KIRKLEES METROPOLITAN COUNCIL INVESTMENT & REGENERATION SERVICE

DELEGATED DECISION TO DETERMINE PLANNING APPLICATIONS

Reference No:	2026/62/91118/E
Site Address:	Upper Soothill Community Centre, 1039, Leeds Road, Woodkirk, Dewsbury, WF12 7HY
Description:	Erection of two storey front and side extensions with perimeter fencing, access gates and associated alterations (part retrospective)
Recommending Officer:	Elenya Jackson

Officer Report.

DRAWING NUMBER	REV
(20) - 001	A

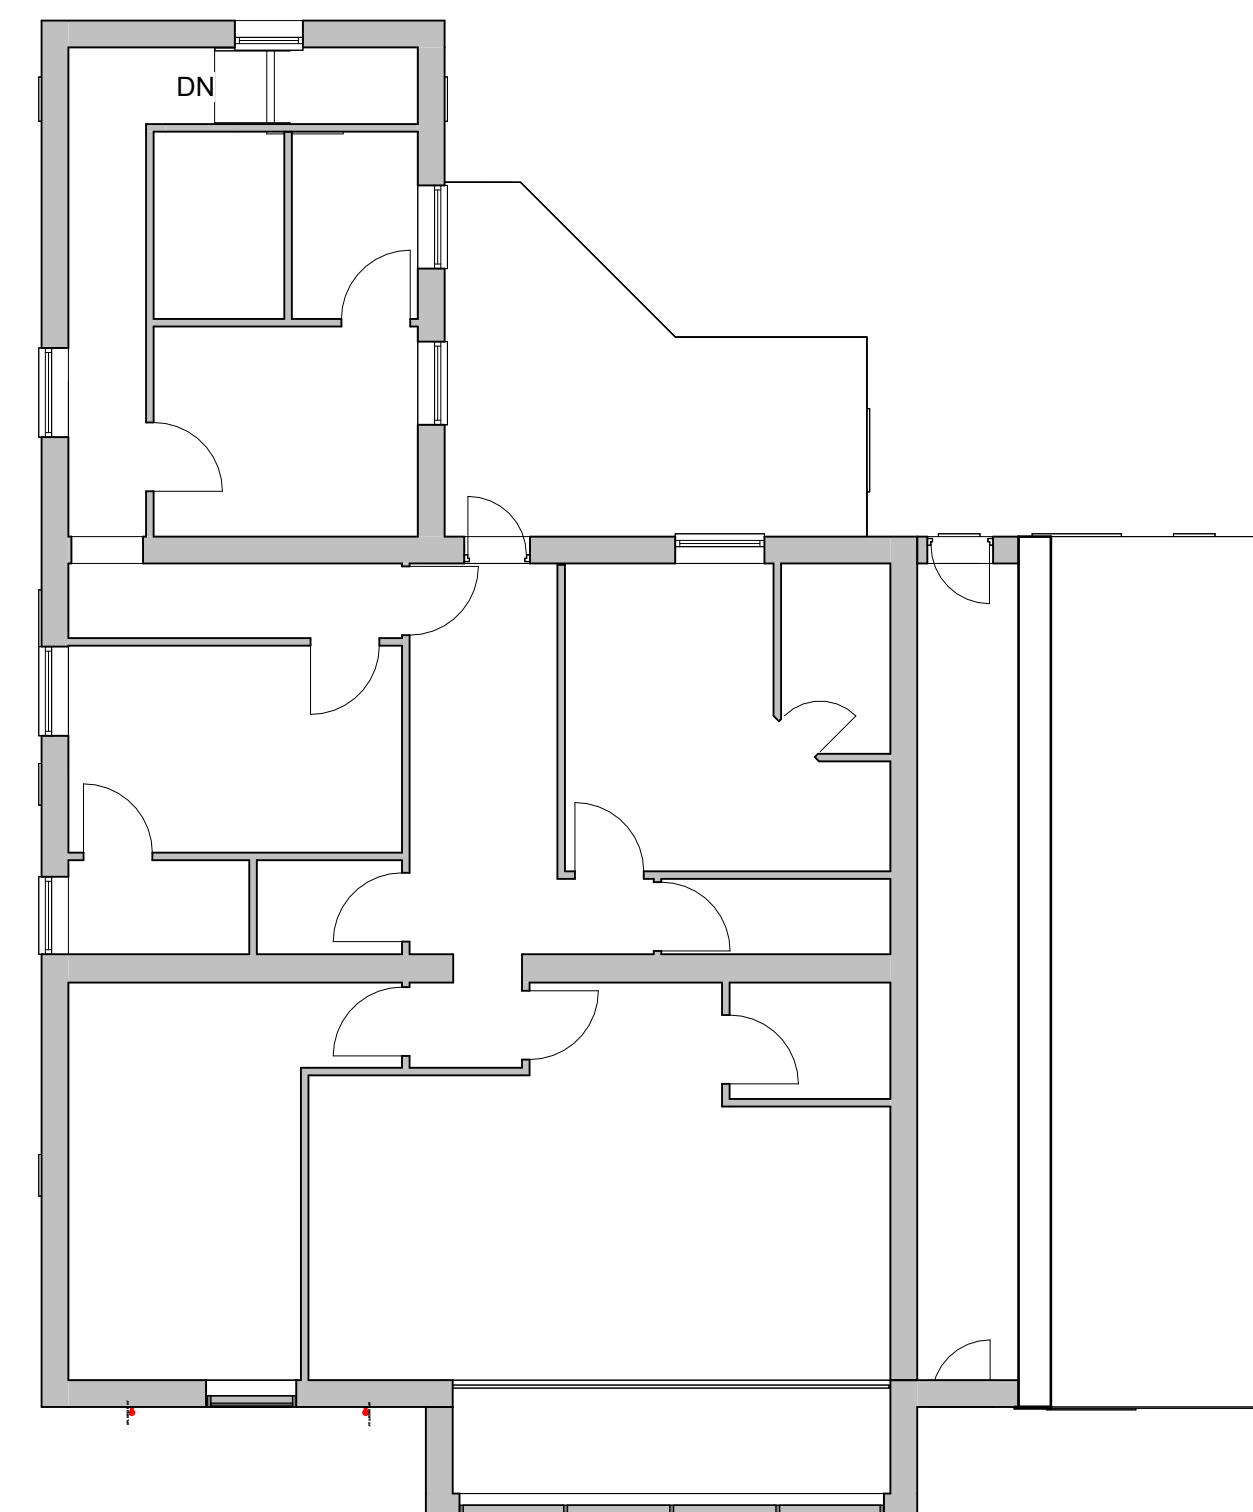
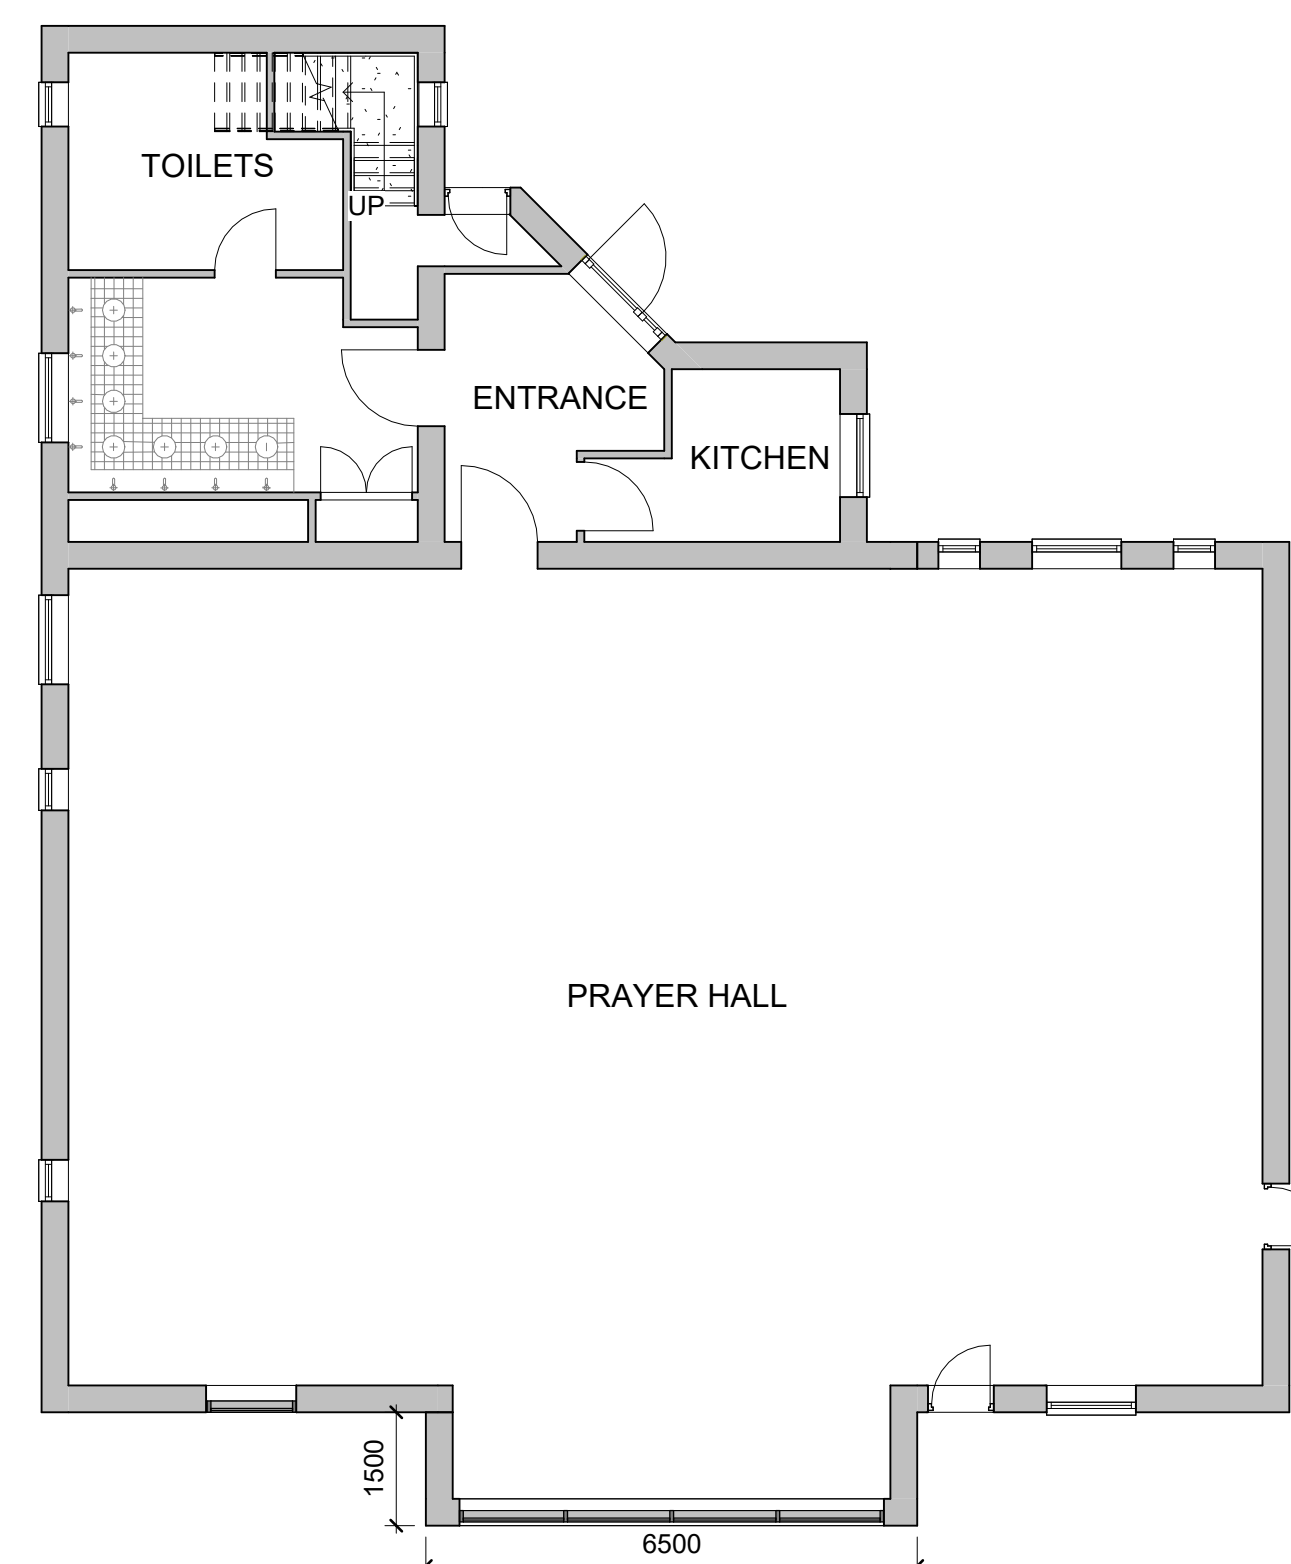
The proposed front extension would extend 1.5m beyond the principal elevation of the building and have a width of 6.5m.

Officers requested the removal of the side extension. Amended plans were forthcoming and the application was progressed on this basis.

The previously approved extension also extended 1.5m beyond the front of the host dwelling and had a width of 4m. The current scheme would have a width of 6.5m. It is considered that the proposed scheme would represent a marginal increase in footprint compared to that of the previously approved scheme.

It is considered that the footprint of the development would only be marginally larger than the two storey projection approved under application 2025/90711 and therefore would not have a substantial impact on the Green Belt.
